July 24, 2018

**RE:** Palmer-Williams Creek Wind and Solar Energy Overlay (WSEO) Application

DWG TITLE:
WSEO Boundary with
Zoning Overlay

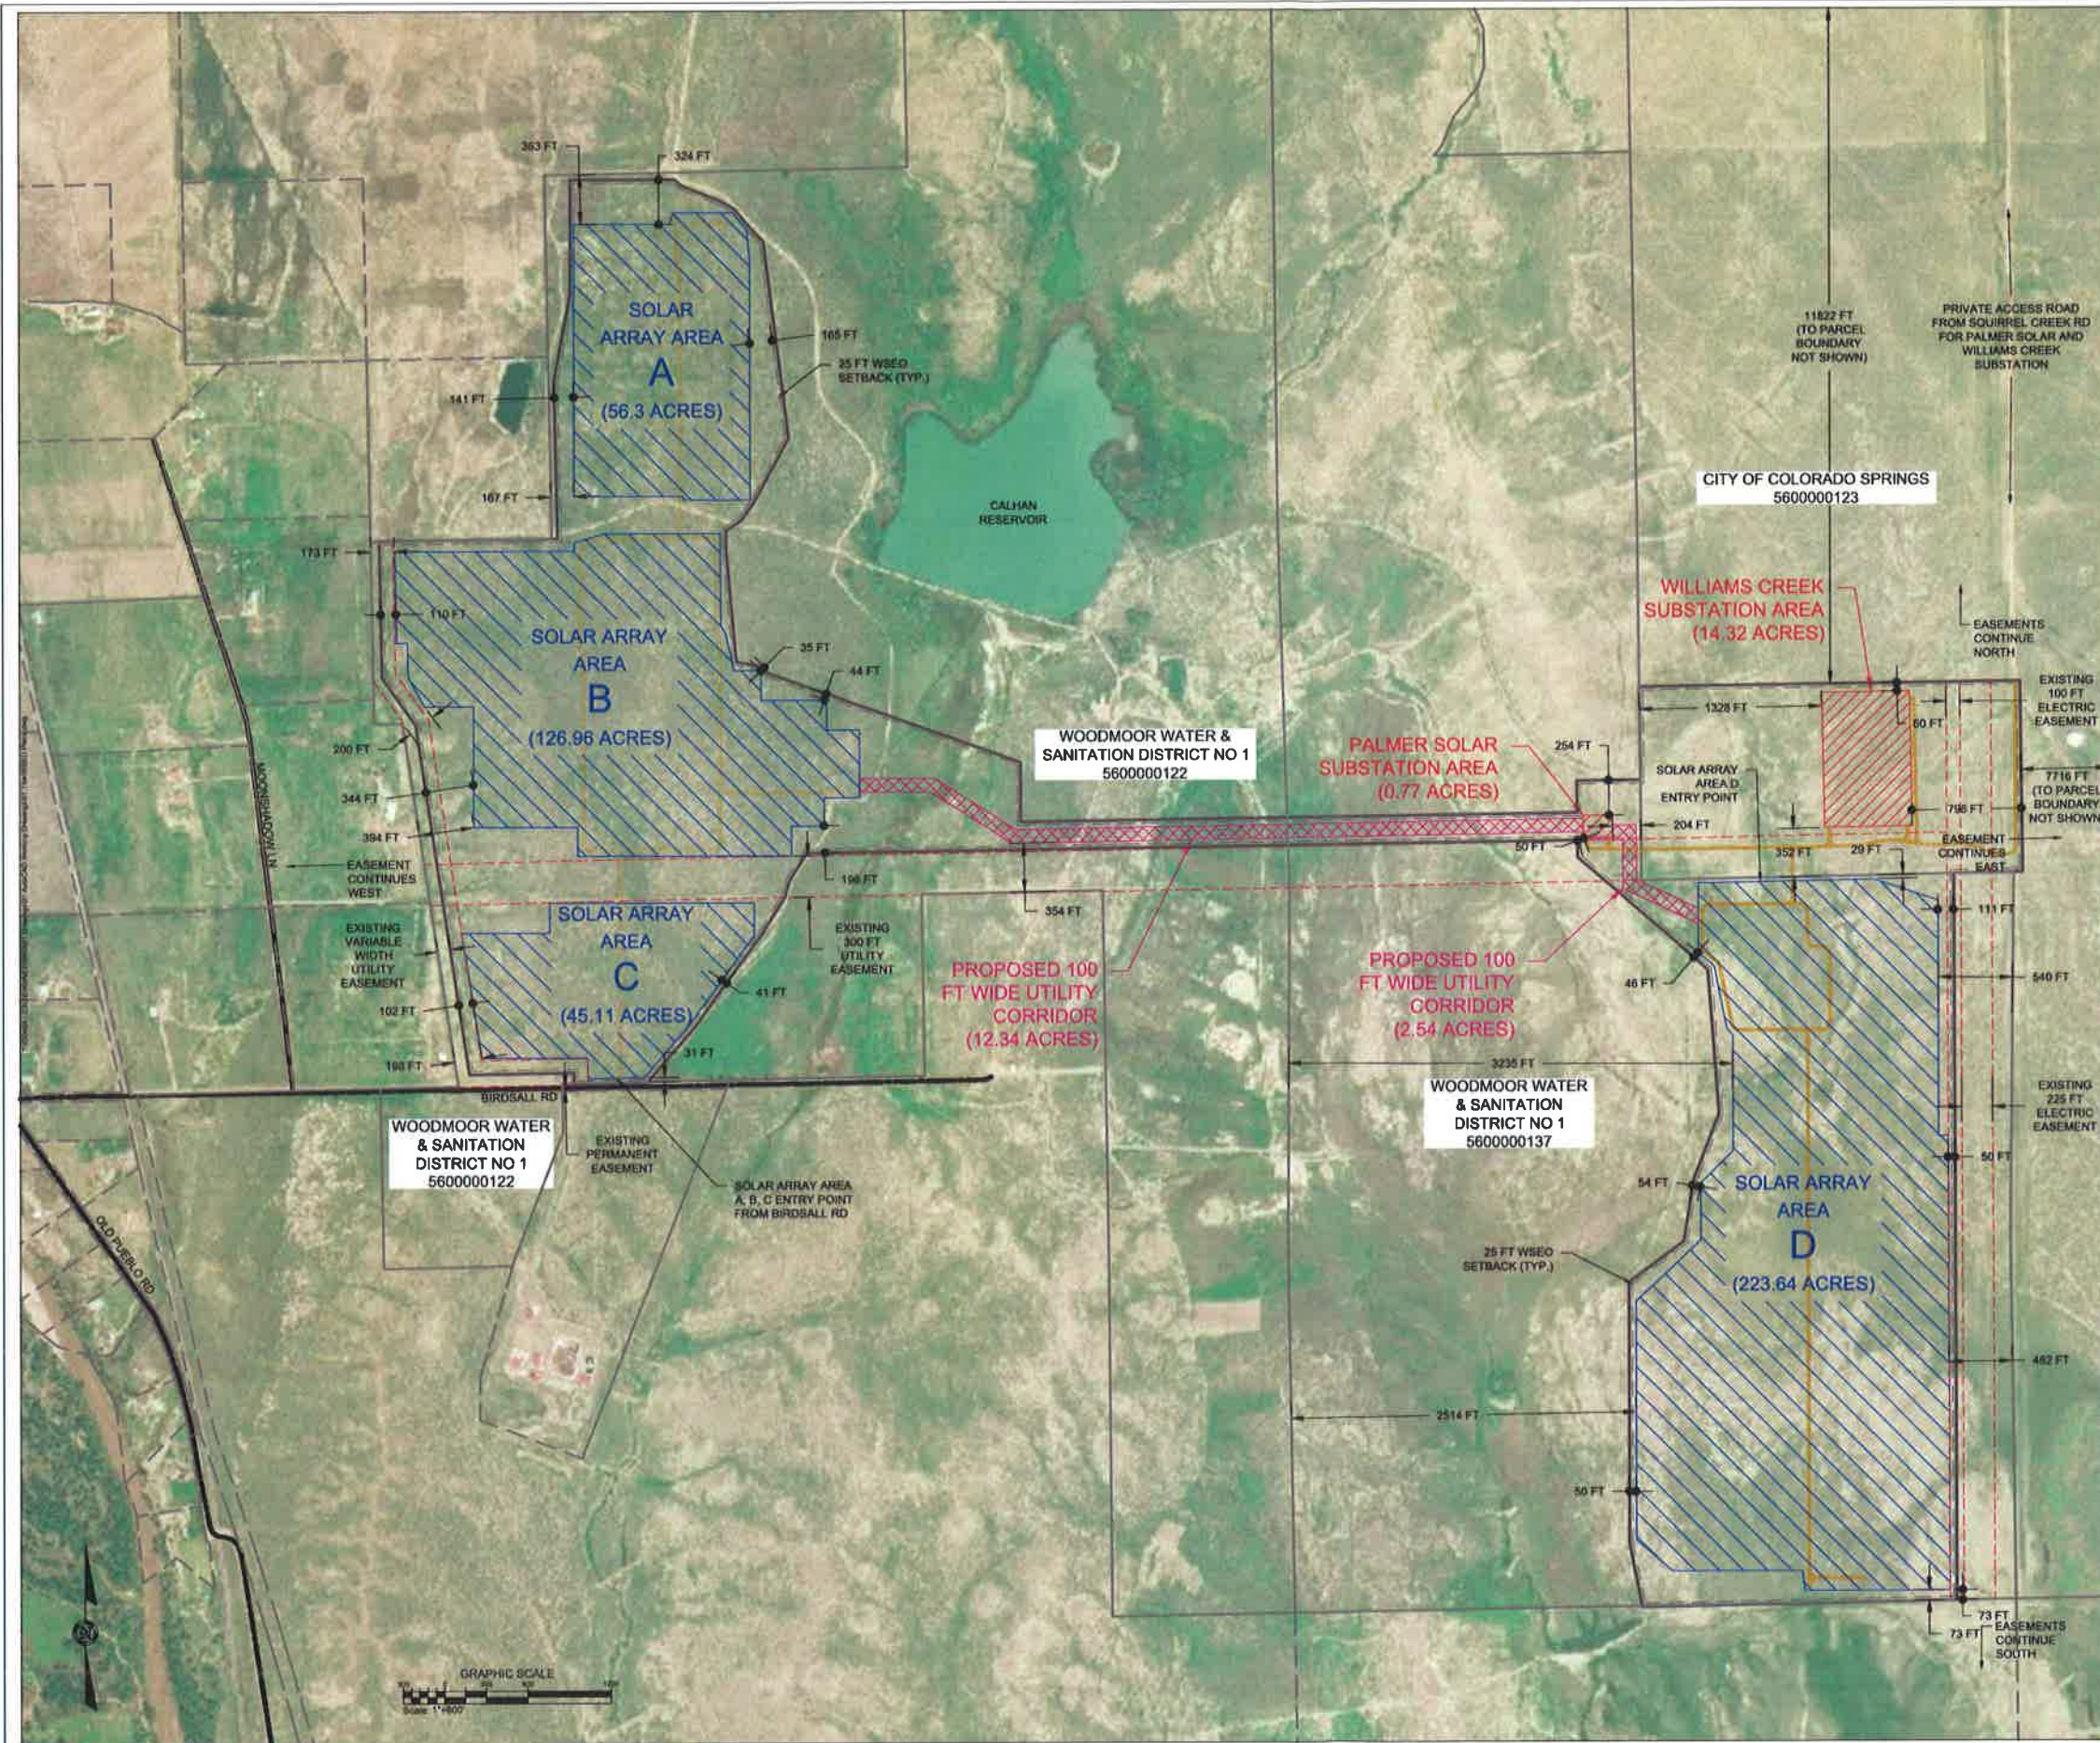
identify the lines on the WSEO map, dimension the substations...

**These should all be clearly identified on WSEO map and setbacks provided for each**

identify corridor on WSEO map {comment applies to all new components}

why can you not bury the line?
